Page No. 2 (C200827)
Haywood County

On Page No. 2, the project special provision entitled "Schedule of Estimated Completion Progress" has been revised. Please void Page No. 2 in your proposal and staple the revised Page No. 2 thereto.

STATE OF NORTH CAROLINA
 DEPARTMENT OF TRANSPORTATION
 RALEIGH
 SUBSTRUCTURE
 BENT NO. 2

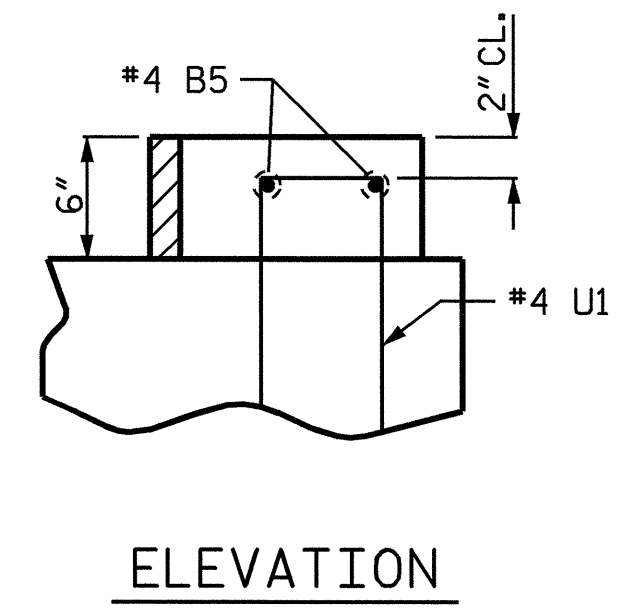
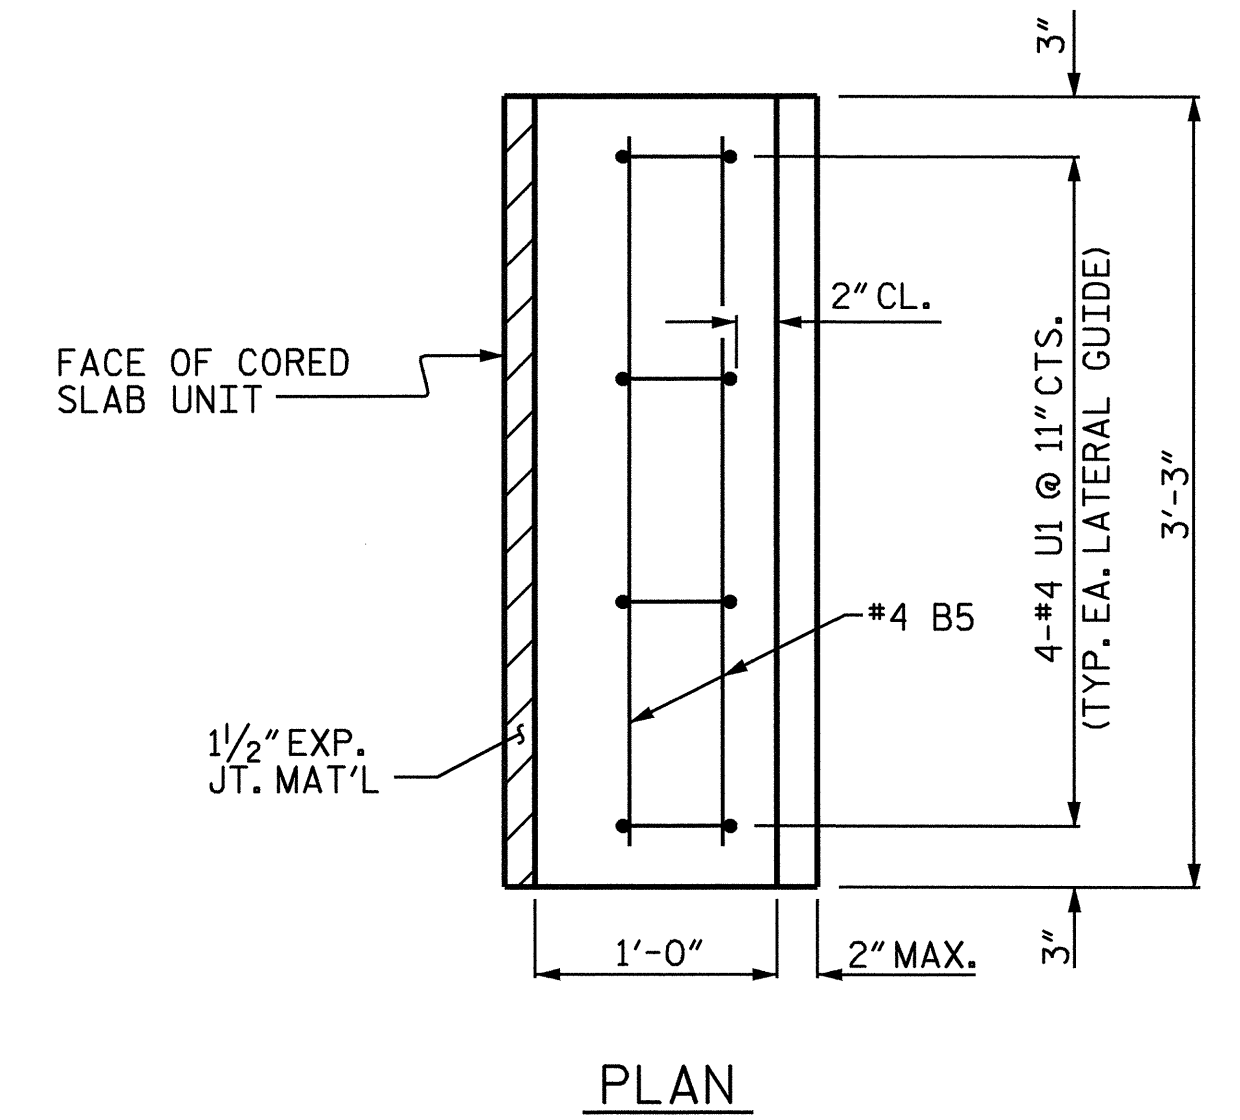
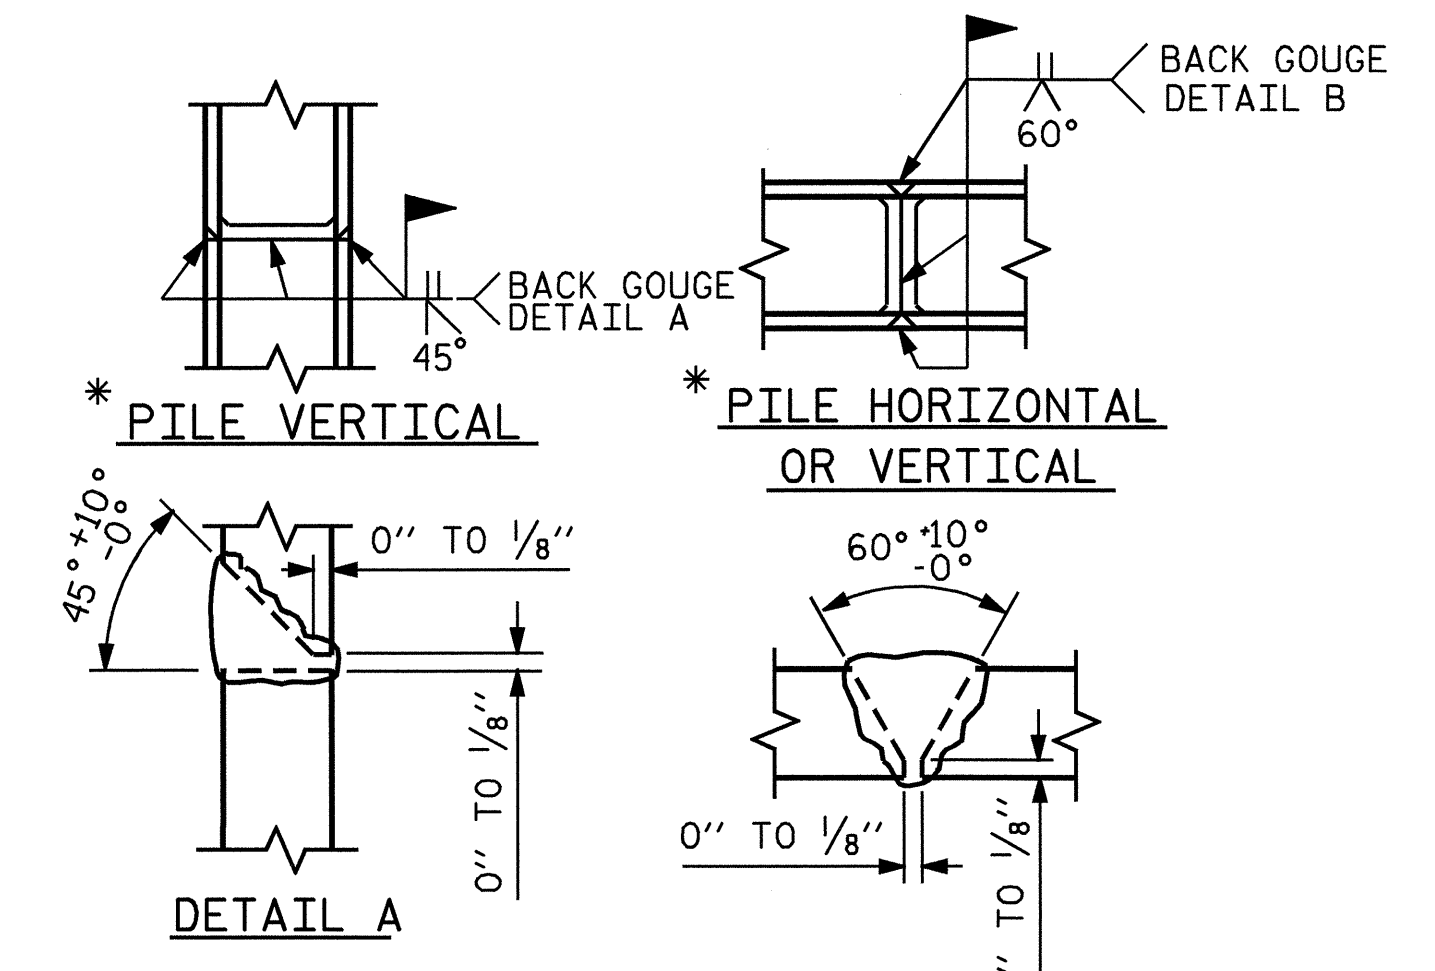
On Page No. 1 of the item sheets, by copy of this addendum line "6-838600000-E-450 PP 18 X 0.50 Steel Piles" is hereby changed to "6-838400000-E-450 HP 14 X 73 Steel Piles (Quantity=510 LF)." The Contractor's bid price must be based on this revised pay item.

Also on Page No. 1 of the item sheets, two new pay items are being added. By copy of this addendum, the following new line items are hereby added: "10-839100000-N-450 Steel Pile Points (Quantity=12EA)" and "11-840600000-N-SP Galvanizing Steel Piles (Quantity=Lump Sum)." The Contractor's bid price must include these new pay items. The contract will be prepared accordingly.
